From: Tom Woolner [REDACTED]
Sent: 09 October 2017 12:55
To: Paul Cann
Cc: Simon Davis; Tim Rainbird
Subject: FW: FW: BE/71/17/PL - Wickes, Bognor Drainage Scheme

Our responses to Paul Cann of Arun Council are as follows:

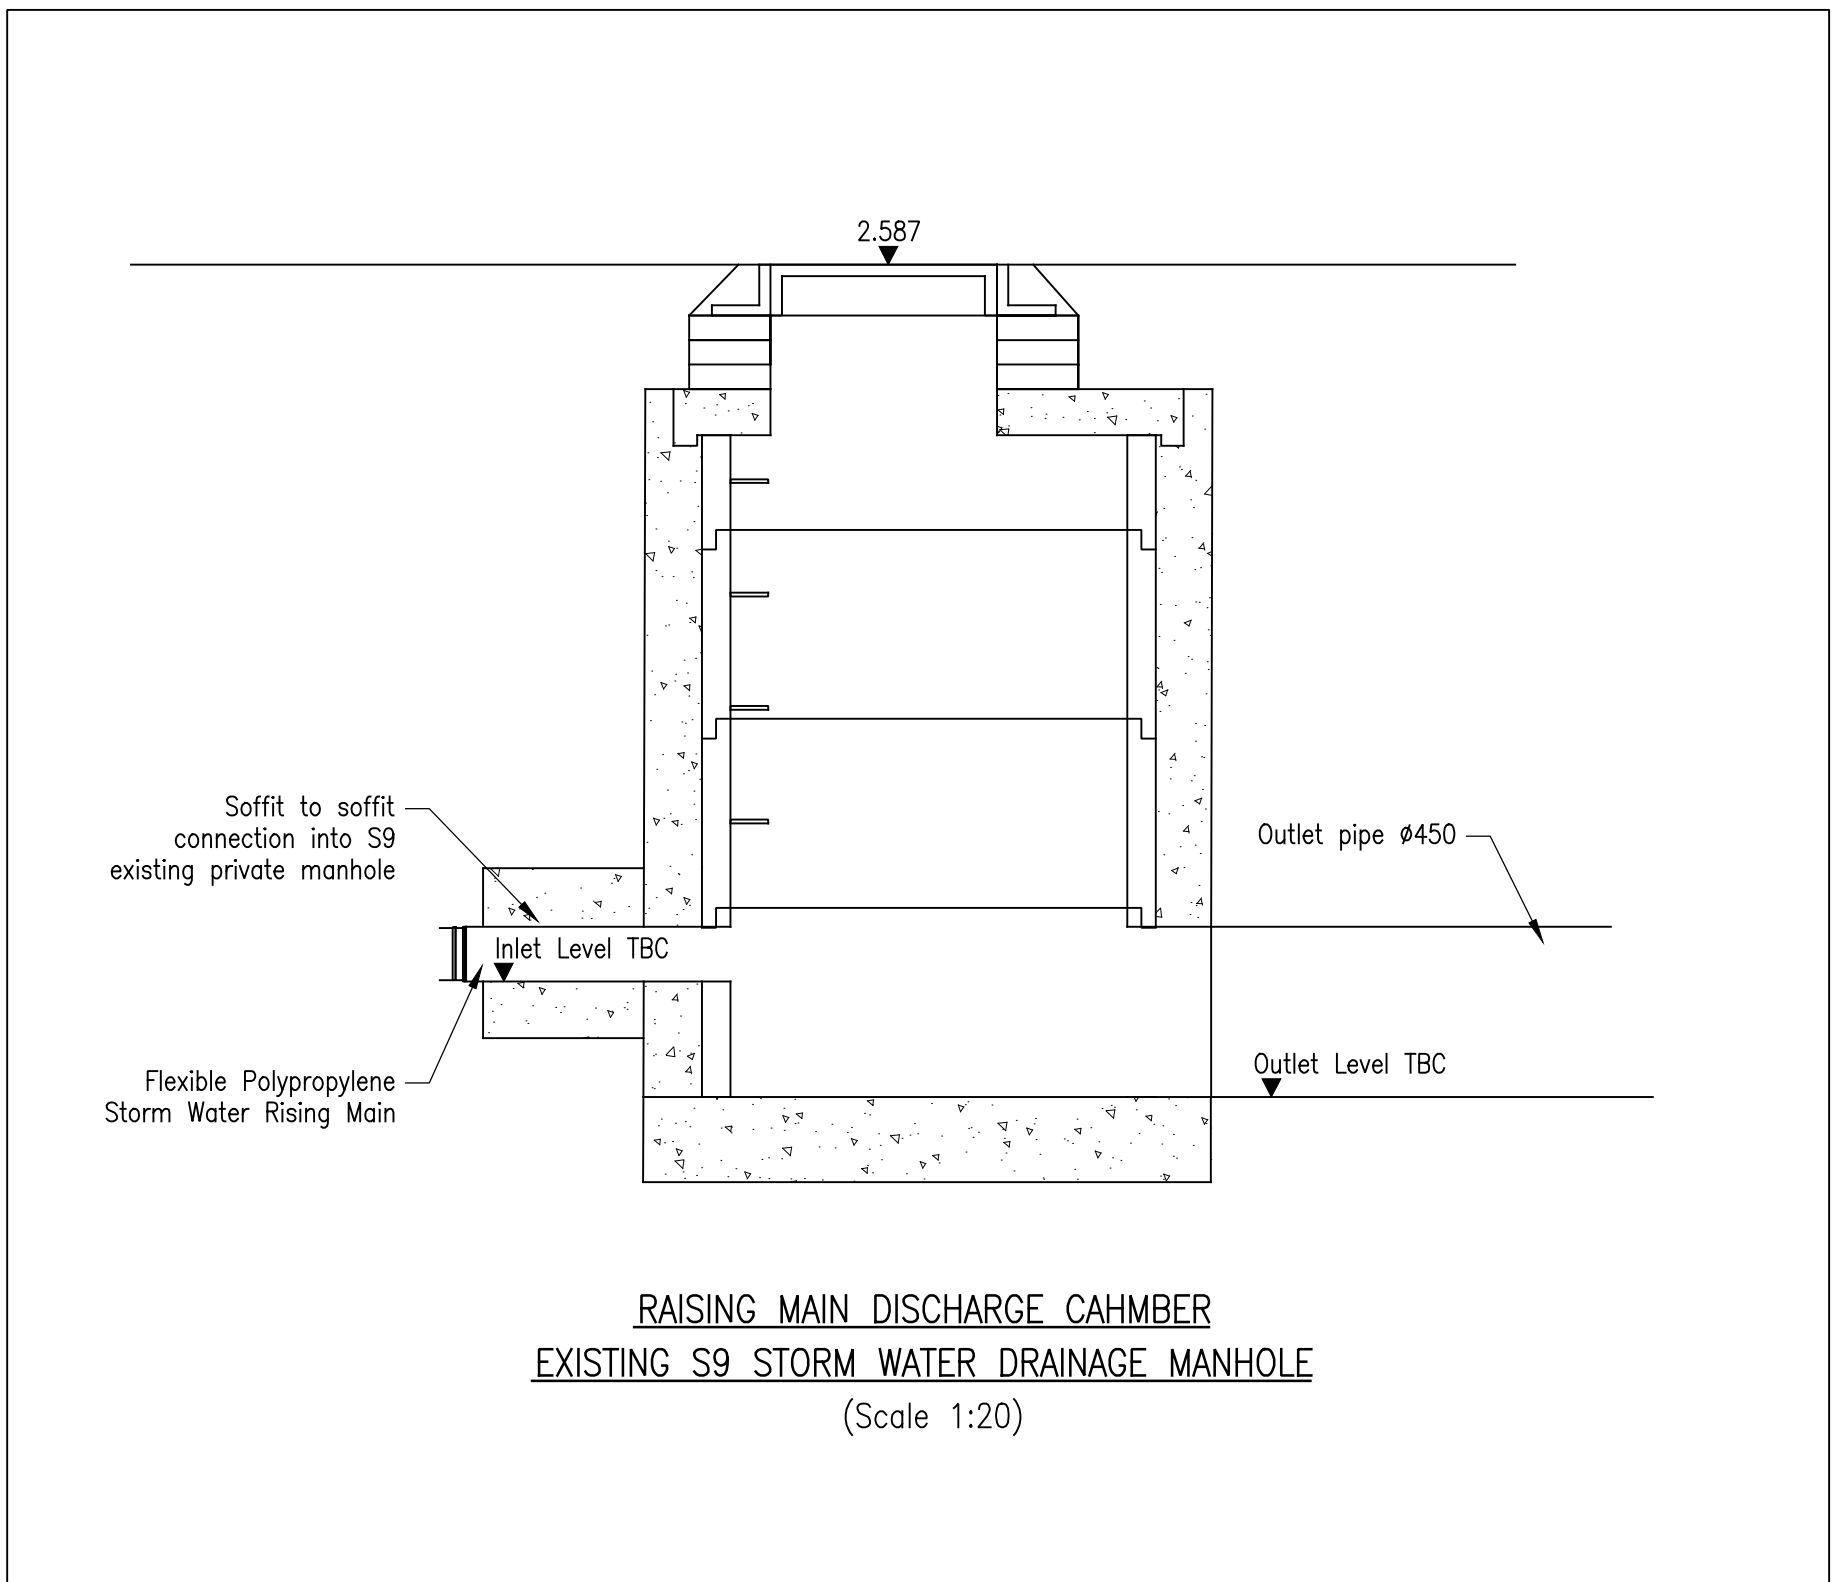
3. The construction detail for the discharge chamber refers to existing manhole S9 and a 450mm outlet pipe. This is not the case. It should show a 250mm diameter rising main with a 375mm diameter outlet. There are some spelling errors too.

SW PACKAGE PUMP

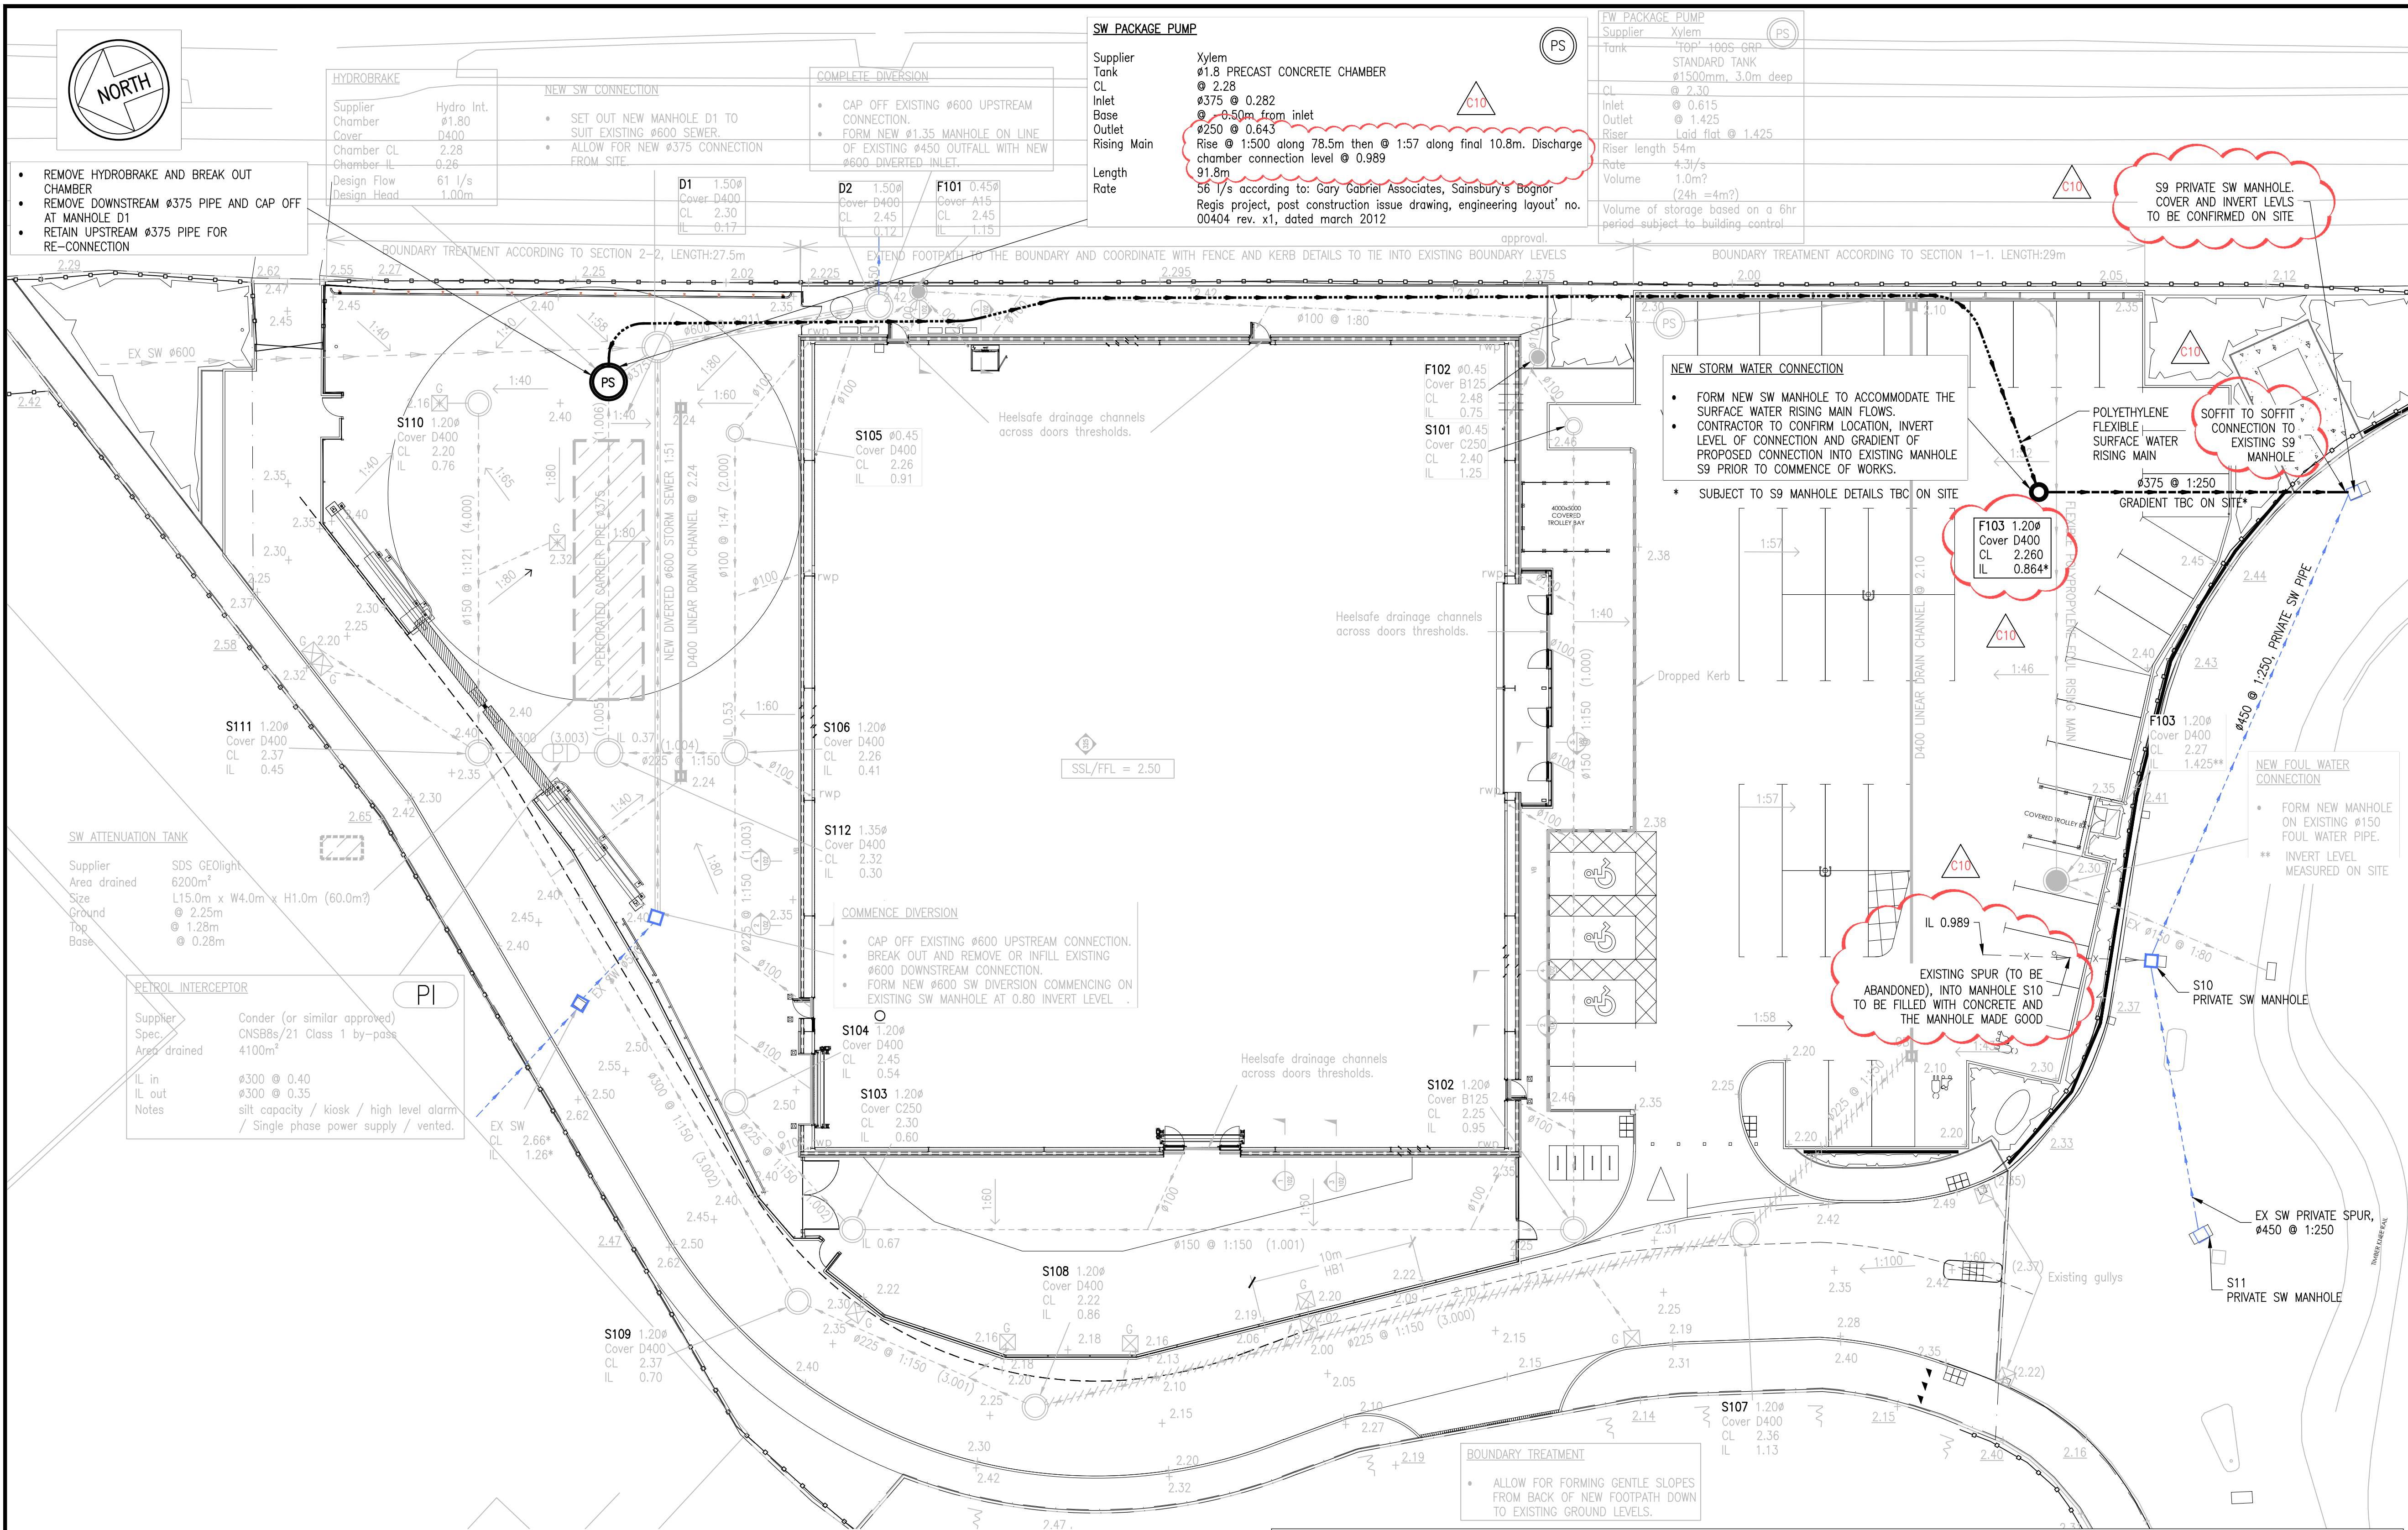
1. Connection to manhole S9 to be made at soffit to soffit level. Specify connection invert level/invert level of existing 450mm pipe.

2. Specify invert levels in discharge chamber. Ie. 0.989 if intending to lay it flat, as per notes? A gradual rise would be preferred though.

4. Improve angle of discharge of the rising main into the discharge chamber ie. not 90 degrees.

5. Existing spur (to be abandoned) into manhole S10 to be filled with concrete and the manhole made good. Add note.

The invert level of existing chamber S9 is unknown and subject to an on-site measurement. Once known any alterations to the upstream design shall be carried out to suit, including a soffit to soffit connection.

Amended to illustrate a gradual rise as attached 300C10

Amended as attached 300C10

Amended as attached 300C10
